Application for Removal or Variation of a Condition following Grant of Planning Permission or Listed Building Consent

Full Planning for Erection of 1no. dwelling and cart lodge.

DC/22/01930

2. Approved Plans & Documents

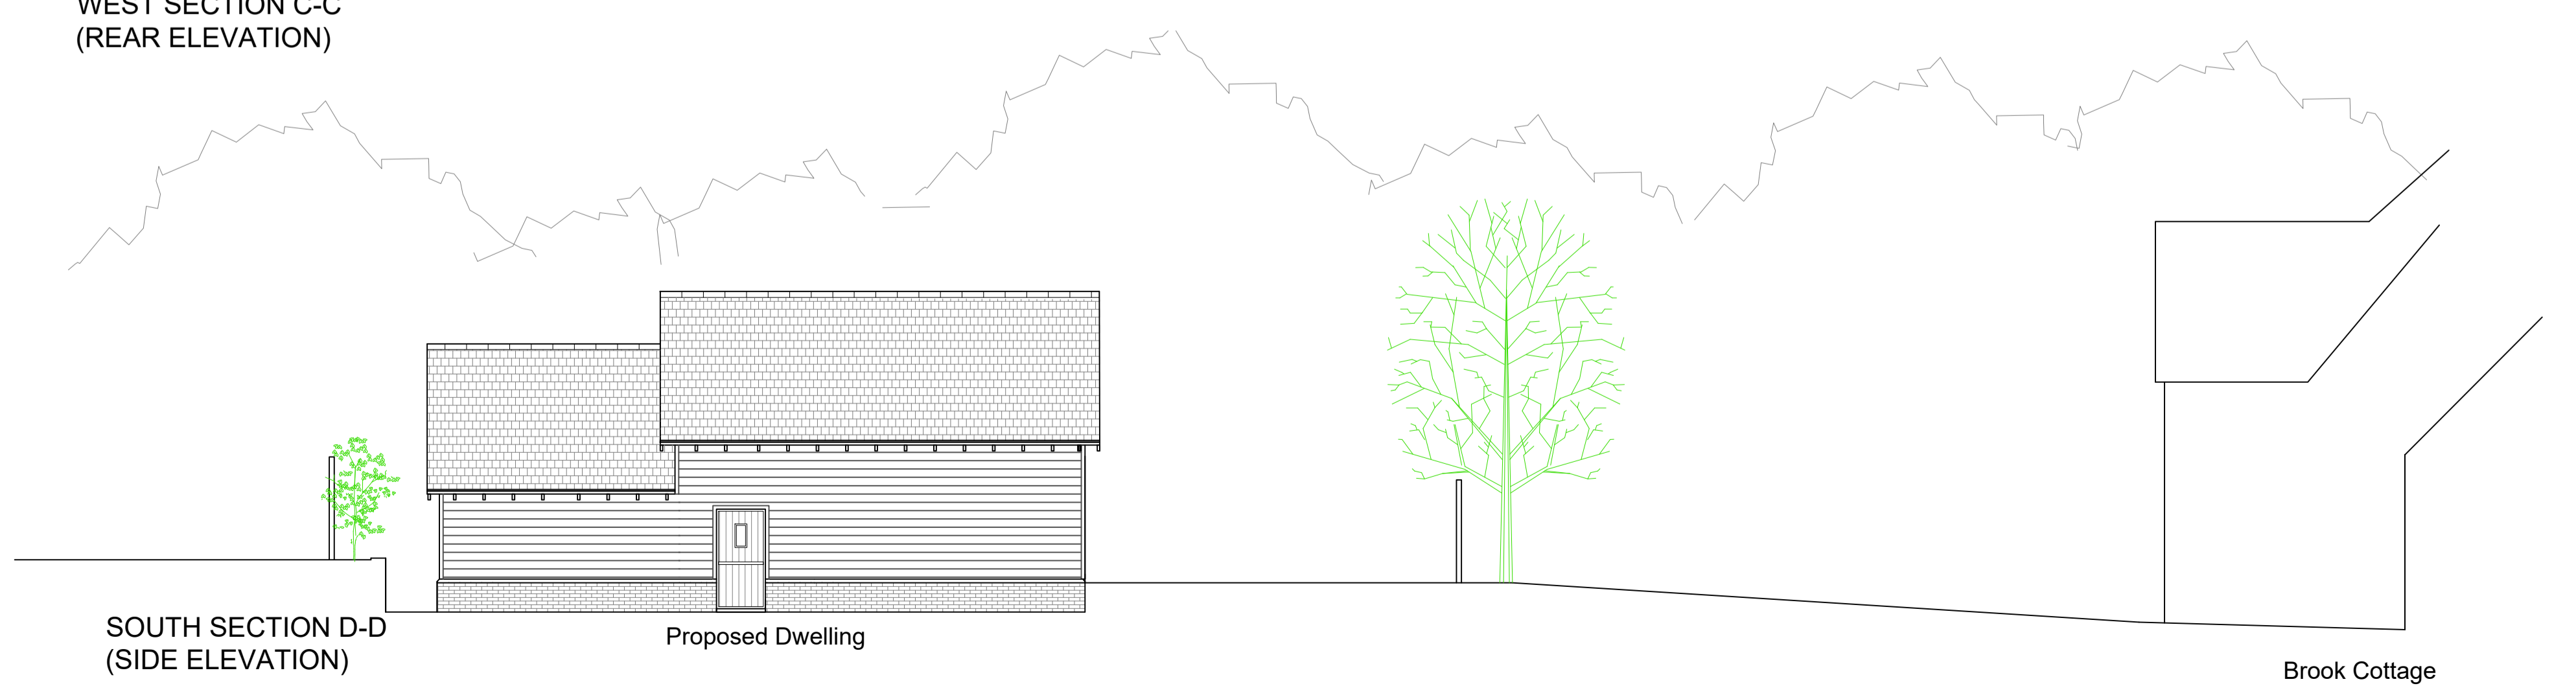
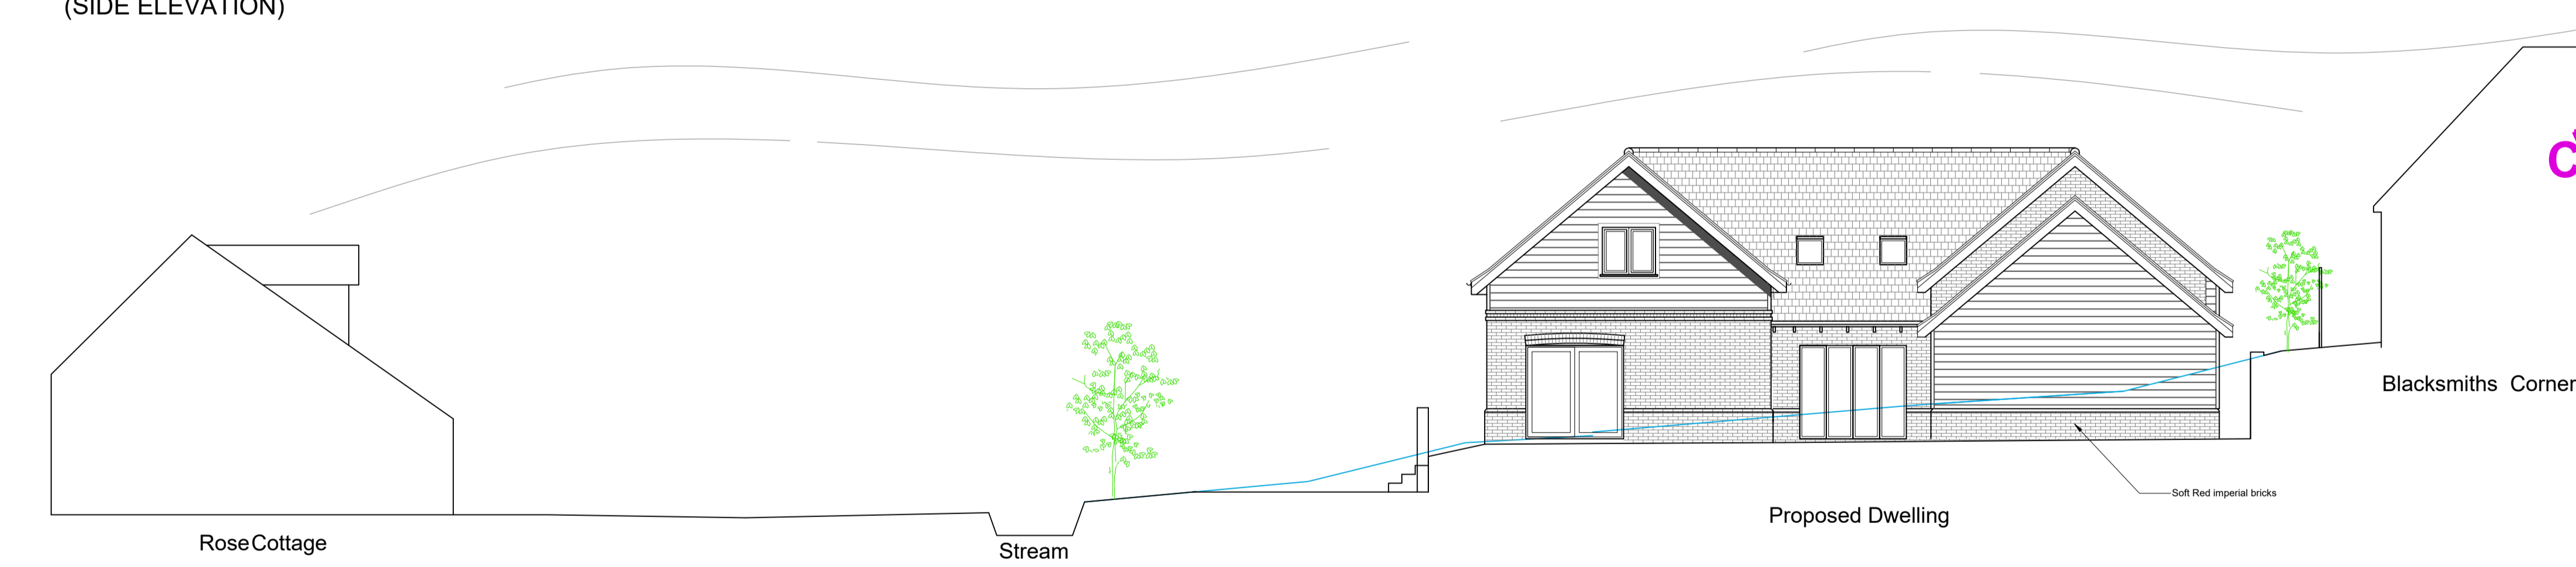
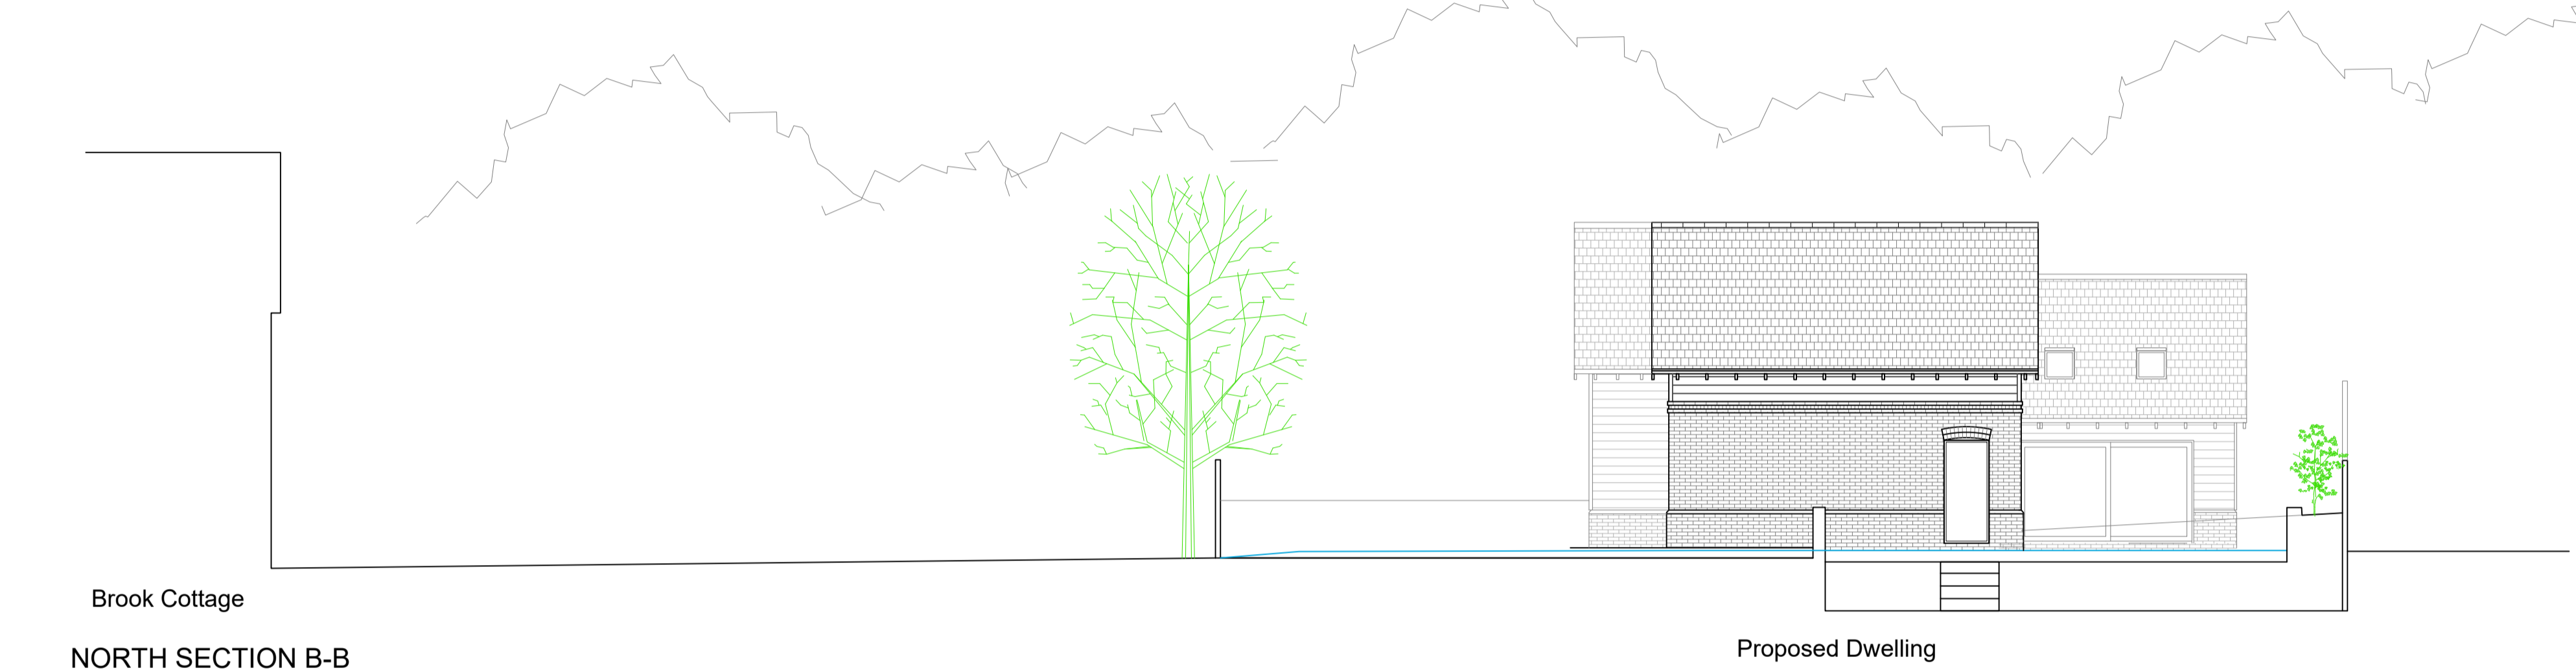
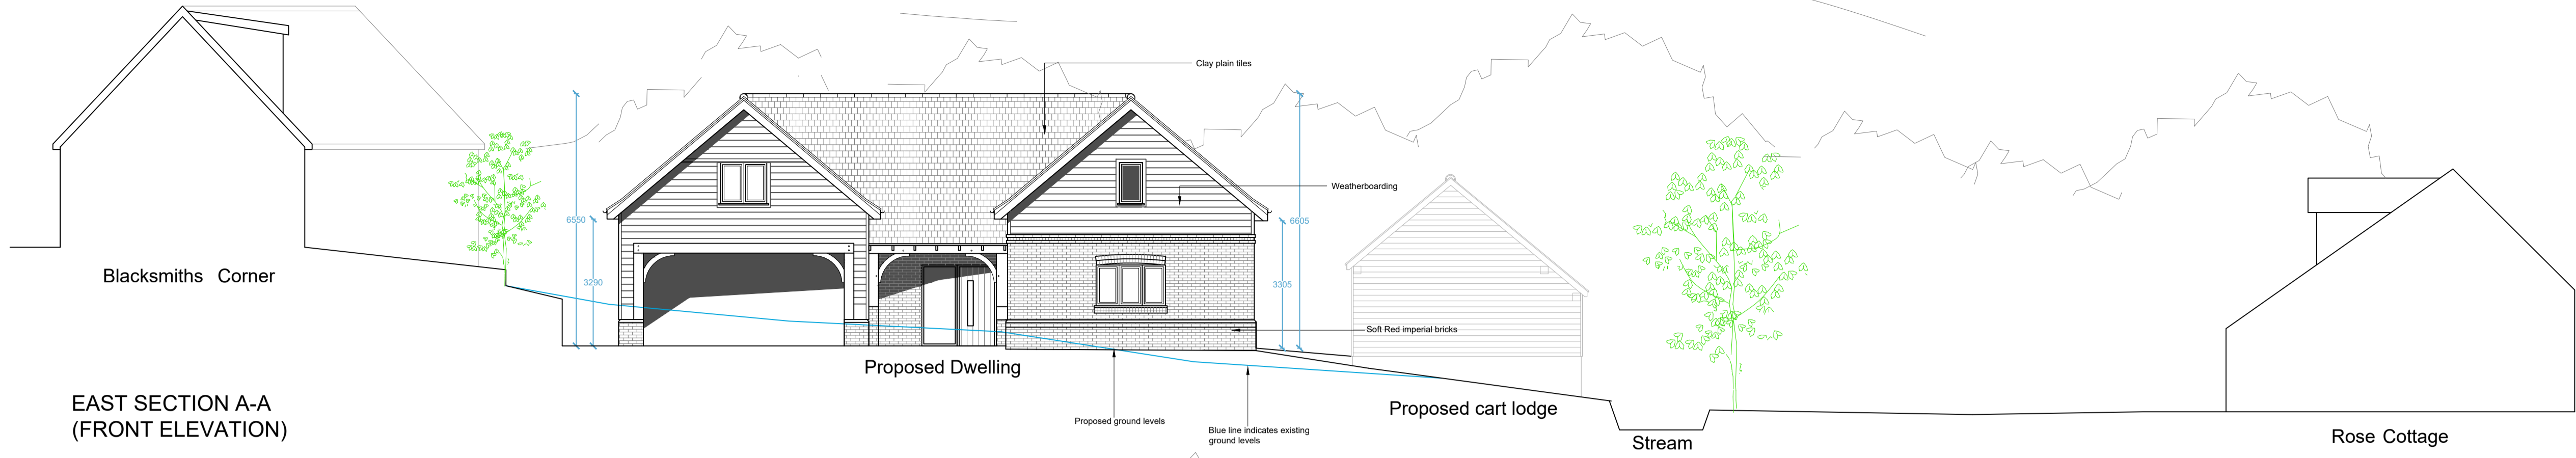
We wish to change the design of the building - mainly to remove the step in the building design and significantly improve accessibility internally and externally. revised plans provided in this application. Also to increase the width of the single-storey part of the building, replace the utility window with a door, utilise the same style of windows throughout the building and remove the central post in the car port.

1. We seek approval to lower the ridge height of the highest part of the building. Excavating the site will enable us to remove the step in the building design and significantly improve accessibility internally and externally.

2. We seek approval to use the same style of windows throughout. We propose to use a style of window without window bars as shown on some of the ground floor windows. This will also give us better options to utilise triple glazed units for energy efficiency.

3. We seek approval to use 2 exterior materials rather than 3 shown on the building design. We propose to use Brick & Weatherboard and not to use Render.

4. We seek approval that we extend the width of the single storey such that the walls and roof ridge lines on the south are aligned . This will involve removing the utility window and inserting a half-glazed utility door. Also to add roof windows on the south elevation of the single storey
